I am writing this submission as a part-owner and resident of a nearby residential apartment building that will be directly affected by the Grocon proposal for a 25-storey building and the modification proposal to SSD7338 (MOD 4) – increase in Construction Hours from the approved 0700-1700 Monday to Saturday to 0600-0000 Monday to Saturday.

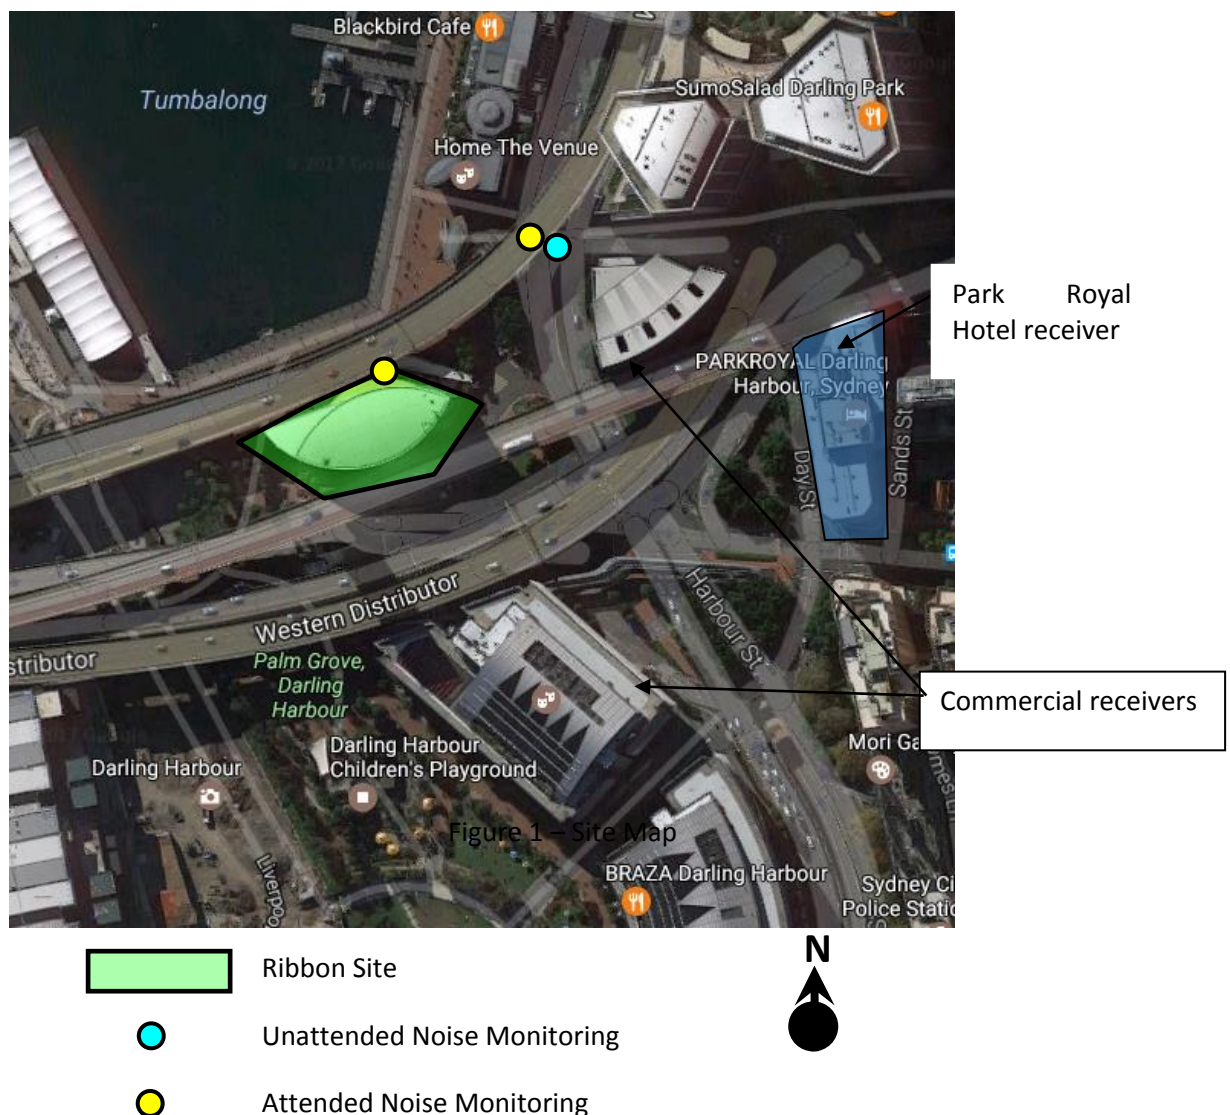
5. The noise assessment does not include a map of where the construction equipment would be located in a 'worst-case scenario'.
6. The noise assessment takes predicated Sound Power Levels from AS2436:1981. The latest version of this standard is AS2436:2010, which includes updated Sound Power levels for various construction equipment as well as the requirement to undertake sleep disturbance assessments.

Unattended Noise Logging Data

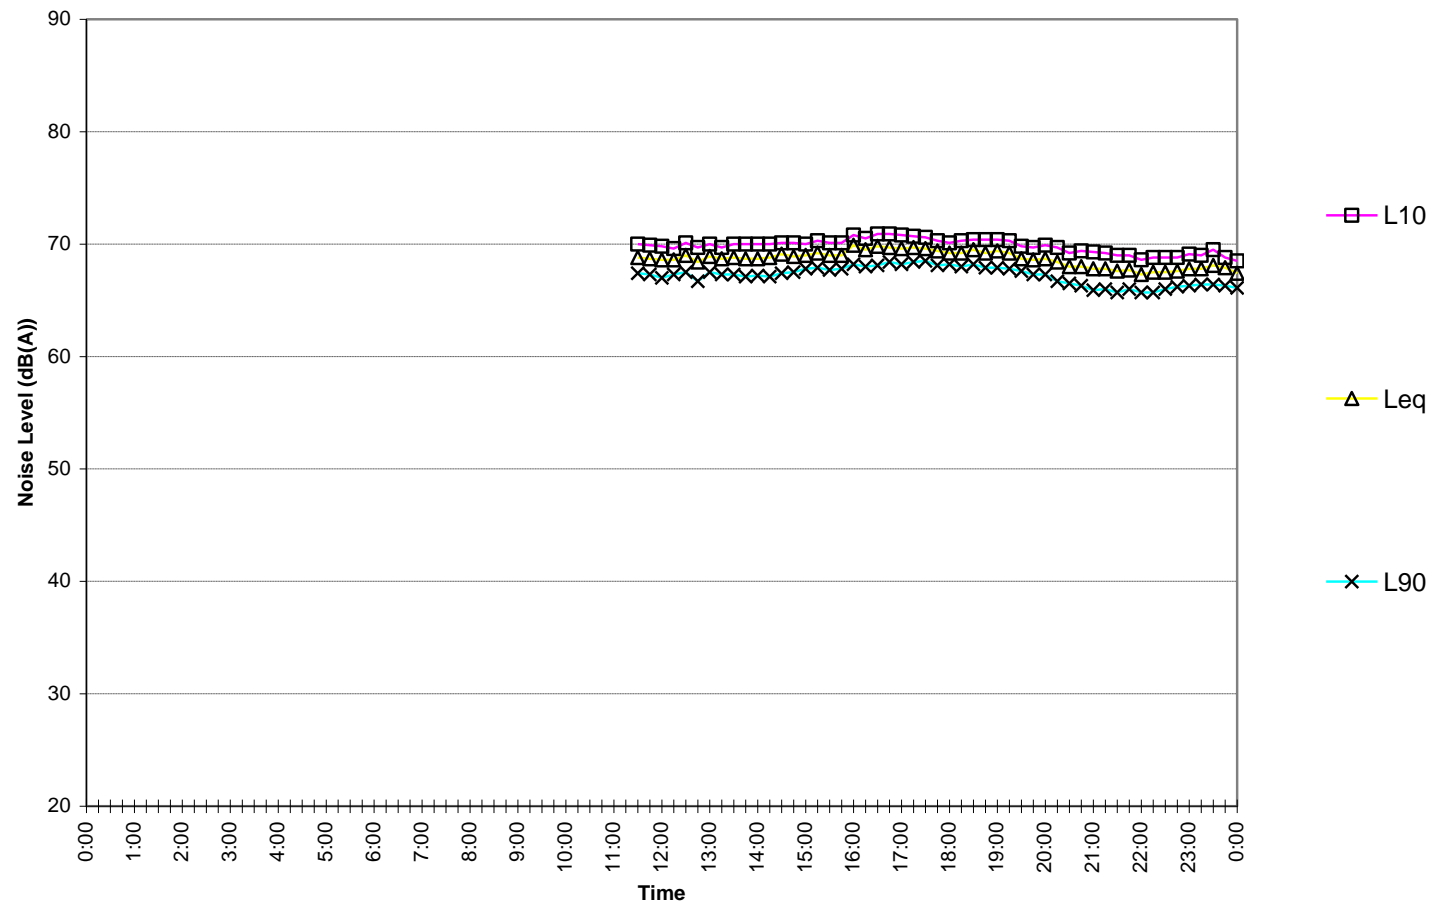
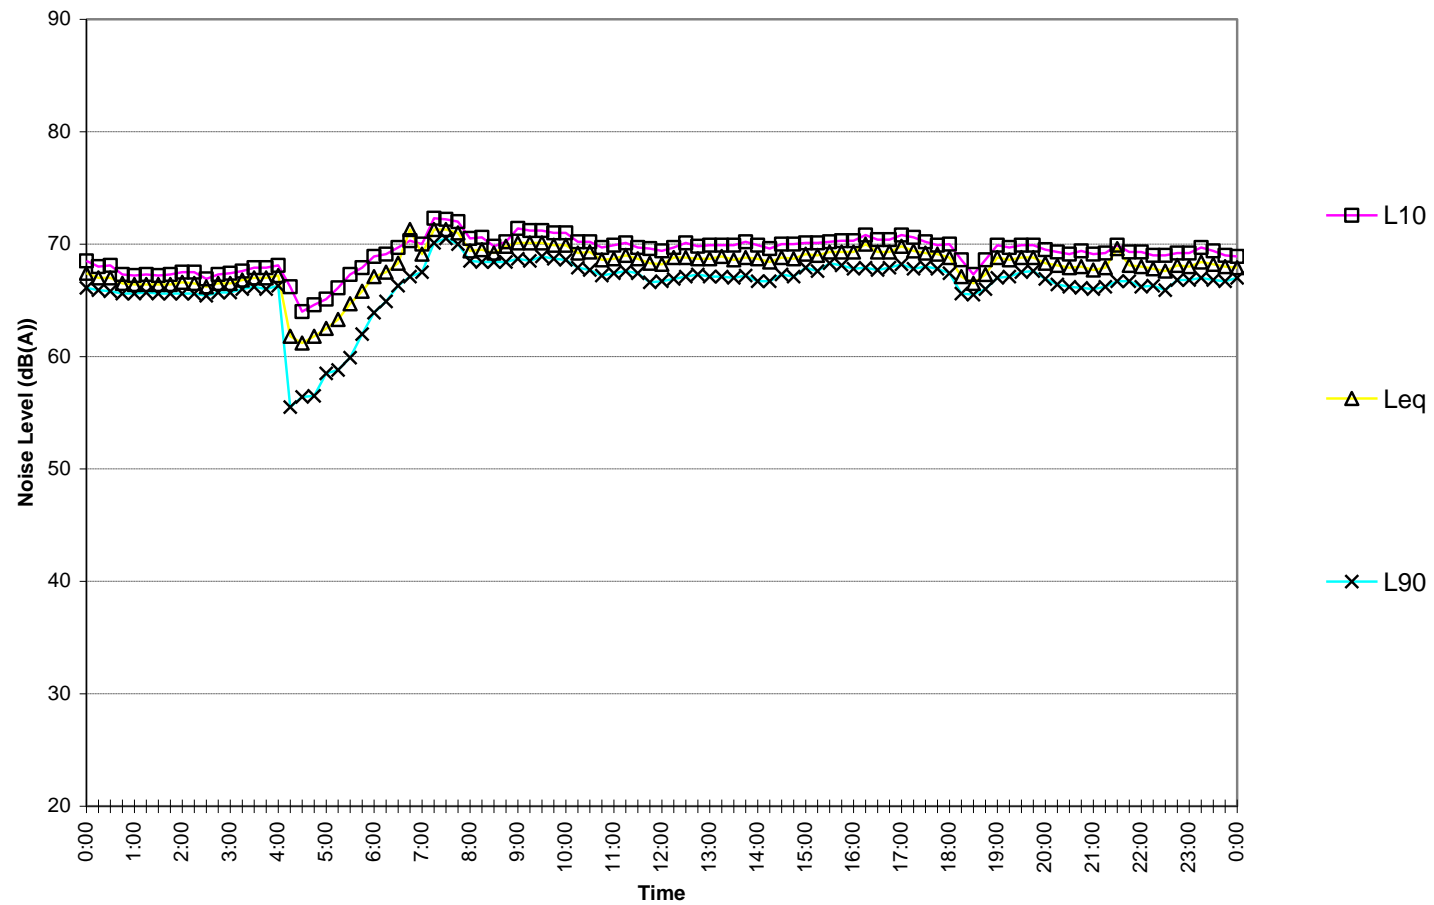
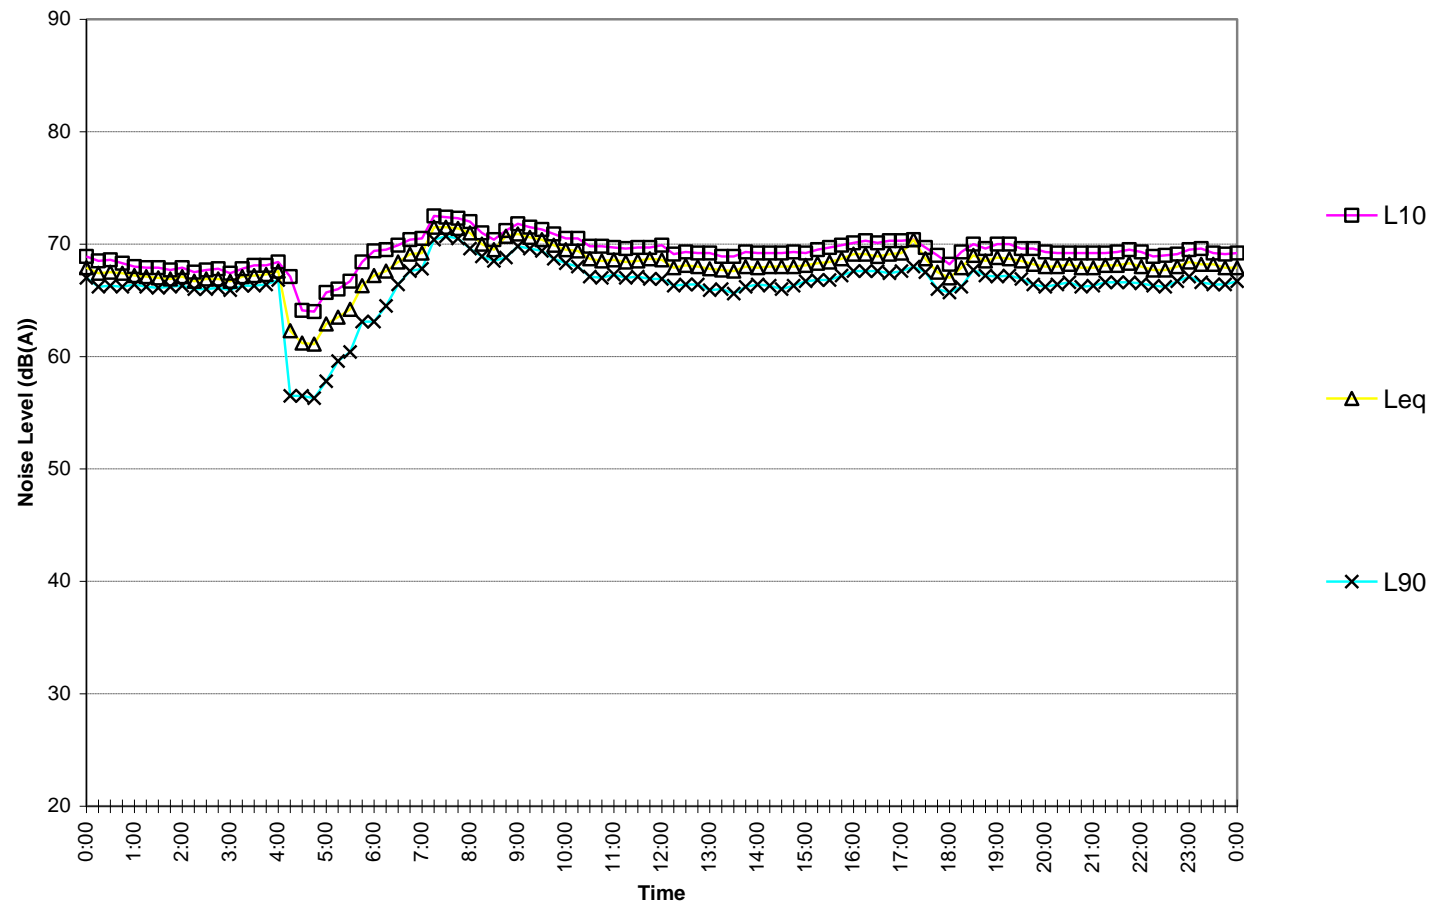
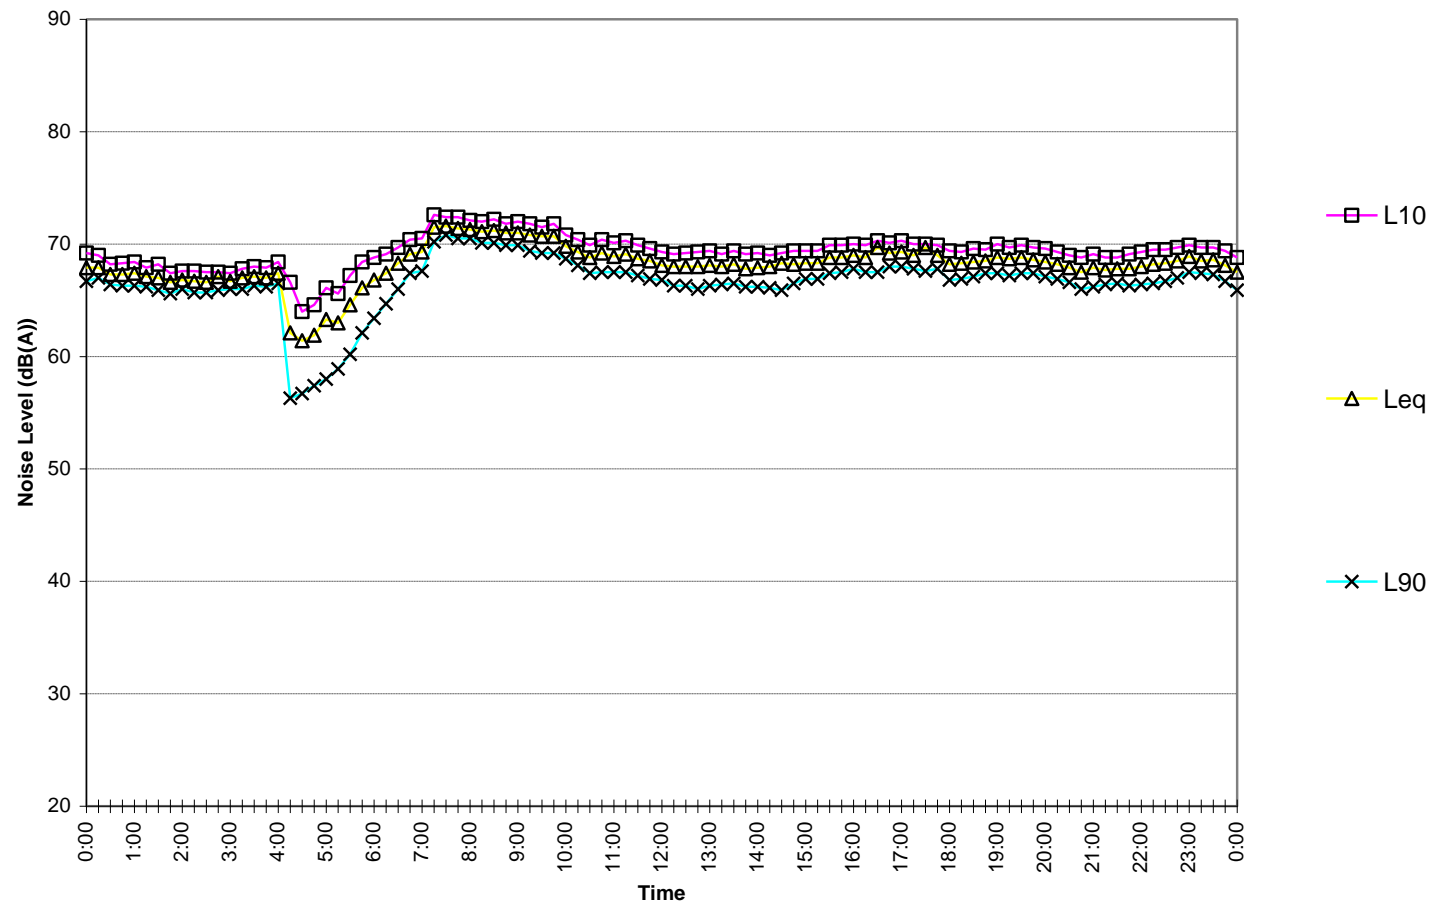
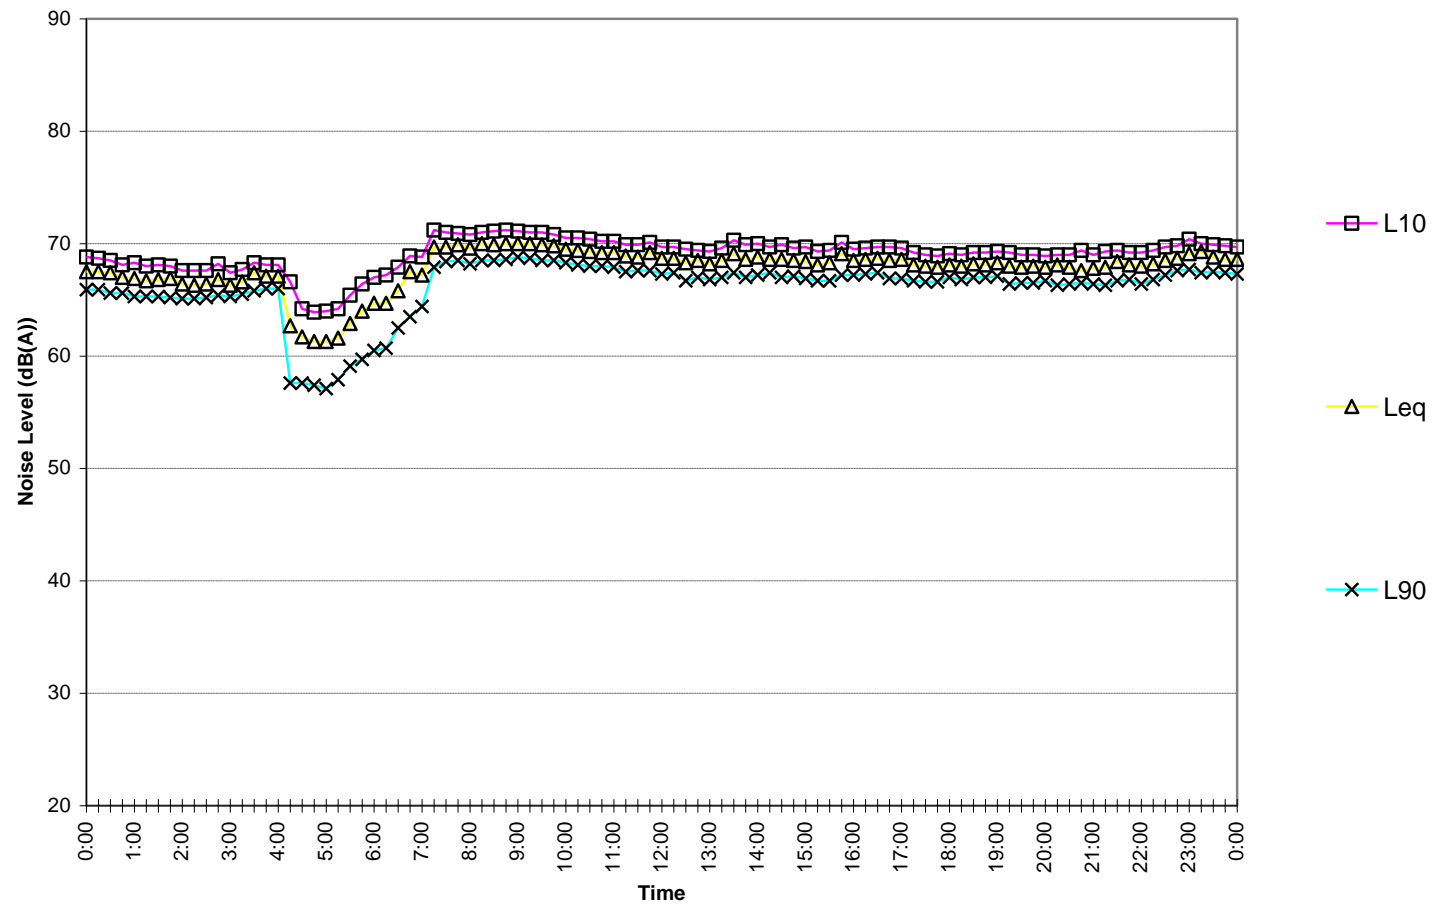
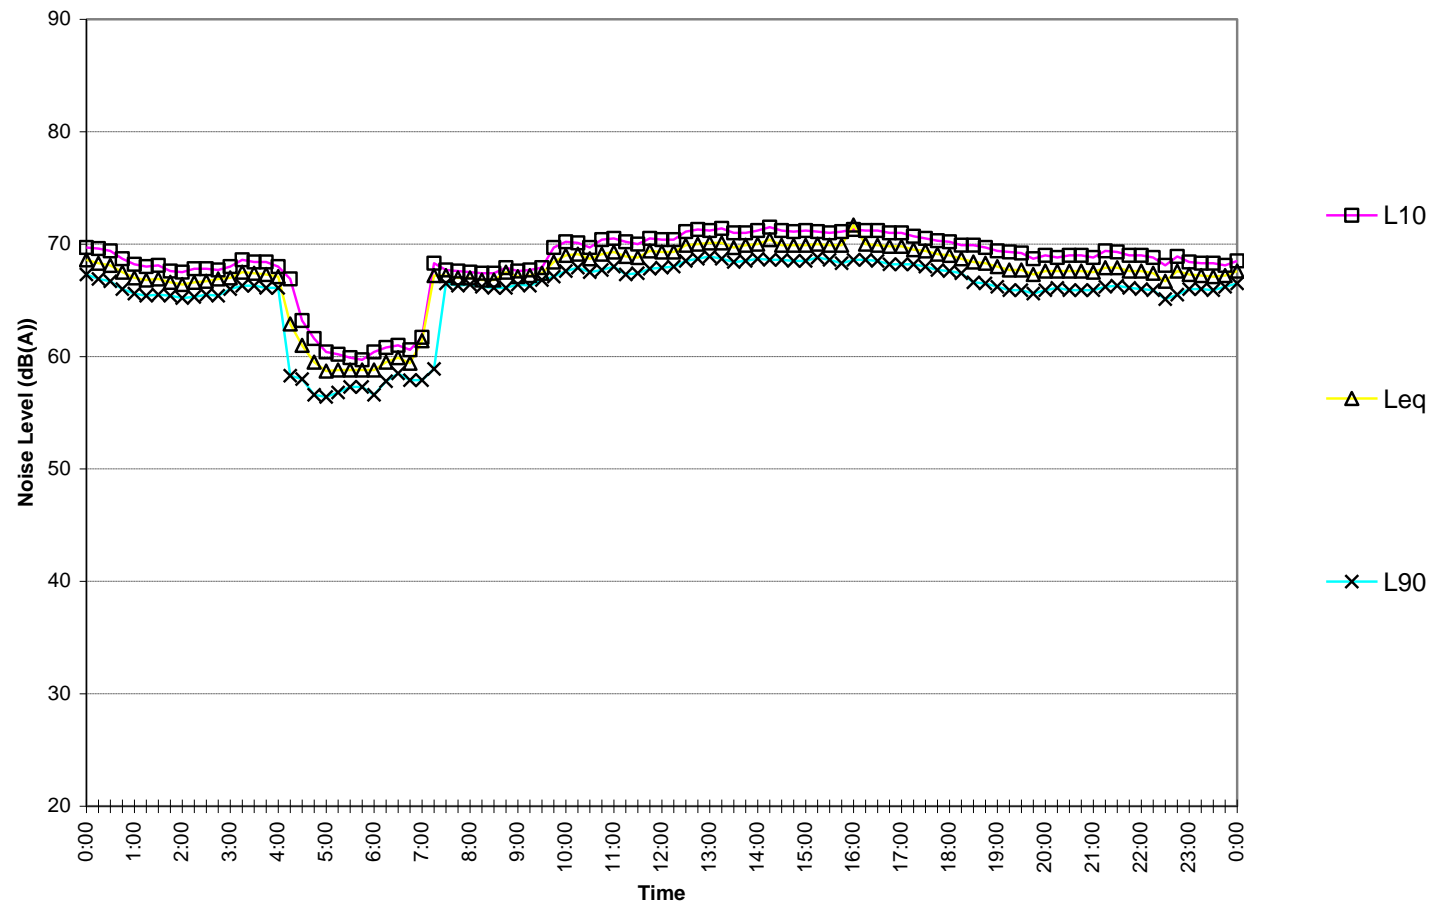
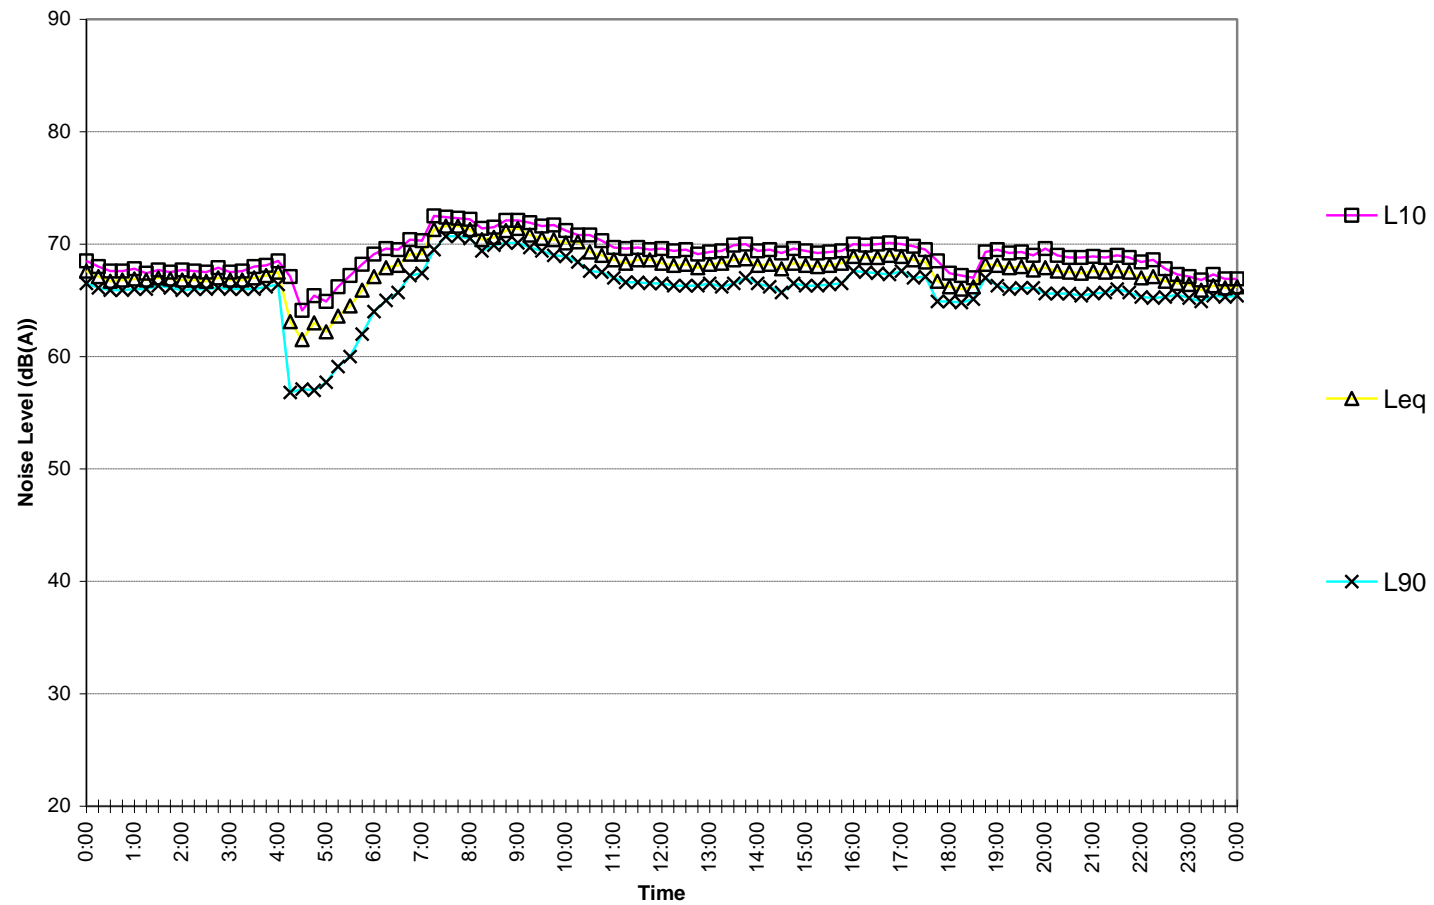
3. There is no Sleep Disturbance Assessment using LA1,1min or LAmax.
4. The Background Noise Monitoring of which the noise assessment is based does not take into account that the background levels are much quieter during weeknights (Sunday to Thursday nights) than on Friday and Saturday nights and it is 5 years old so may not be relevant anymore.
